Householder Application for Planning Permission for works or extension to a dwelling

To extend the existing porch on our bungalow, Rosina, Brewery Road.
The new porch will measure 3.5m x 1.7m and is single storey with a flat roof. The current porch measures 1.7m x 1.7m, again with a flat roof.

IS1/23/1882

Front Elevation (North) - Proposed
scale 1:50

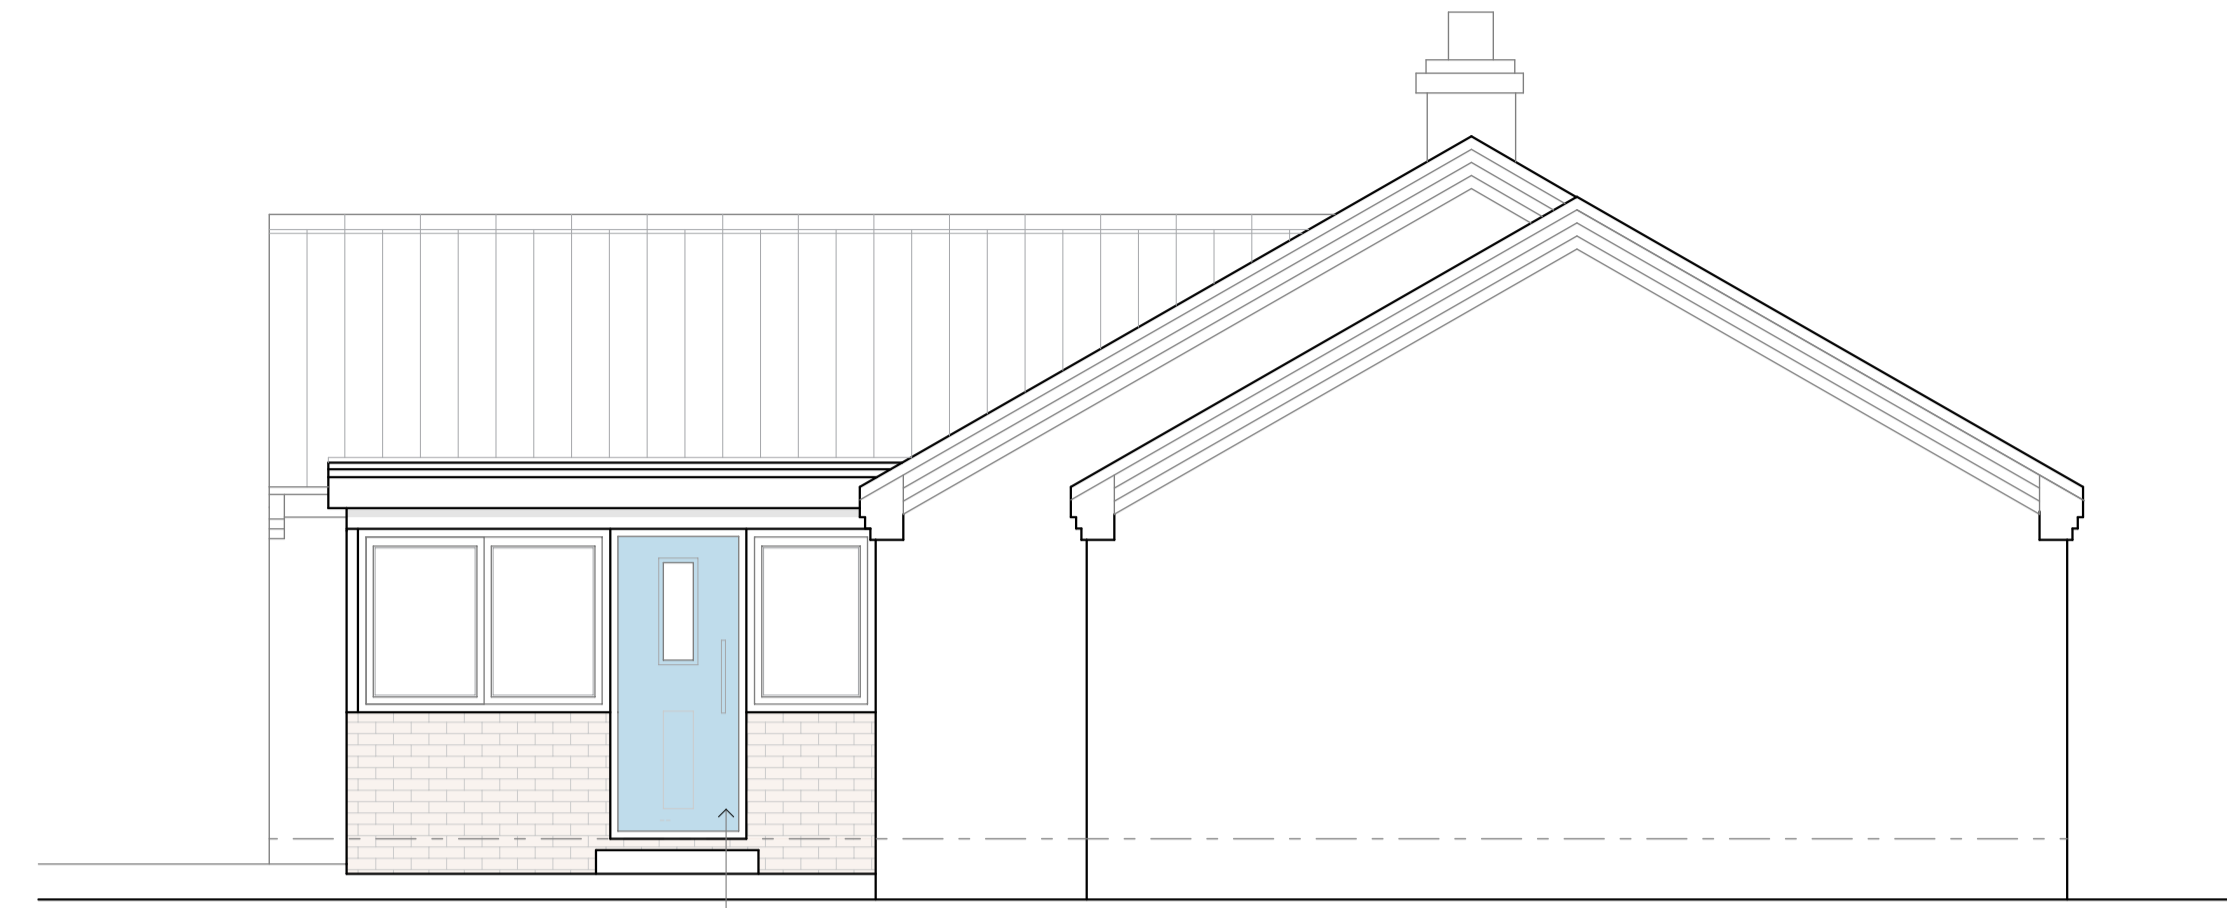
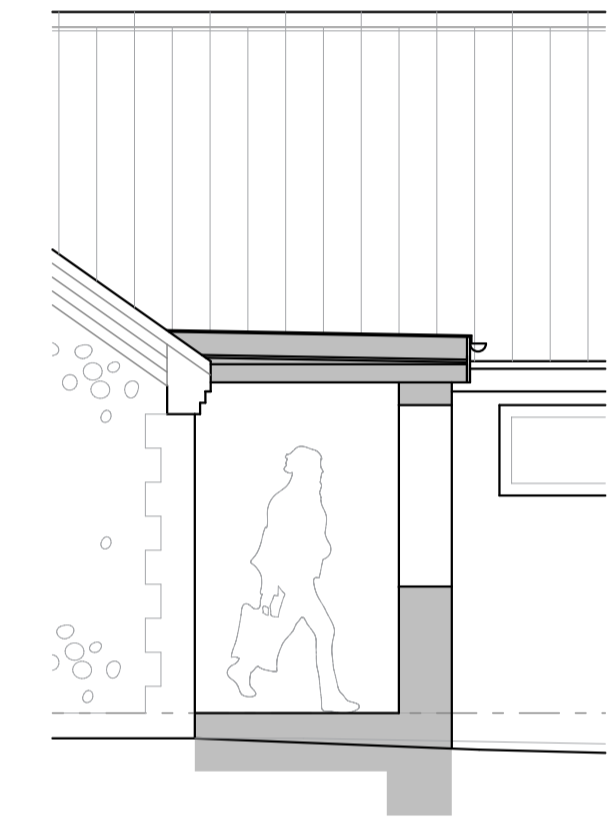
The proposed porch would replace the existing porch, albeit with a larger built form. The size and scale of the proposed porch would prevent a disproportionately large increase in the height or scale of the original dwelling and it would not materially increase the impact of the dwelling on the appearance of the surrounding countryside.

Although flat roof forms are not normally considered acceptable, as detailed in the North Norfolk Design Guide, the relatively small scale of the proposal would likely prevent a significant objection, in this regard. Furthermore, the existence of the existing flat roof porch, coupled with the compatible materials proposed, would likely help to further prevent an objection.

The location of the porch on the front elevation and its location in relation to neighbouring properties would likely prevent significant concerns being raised in relation to residential amenities.
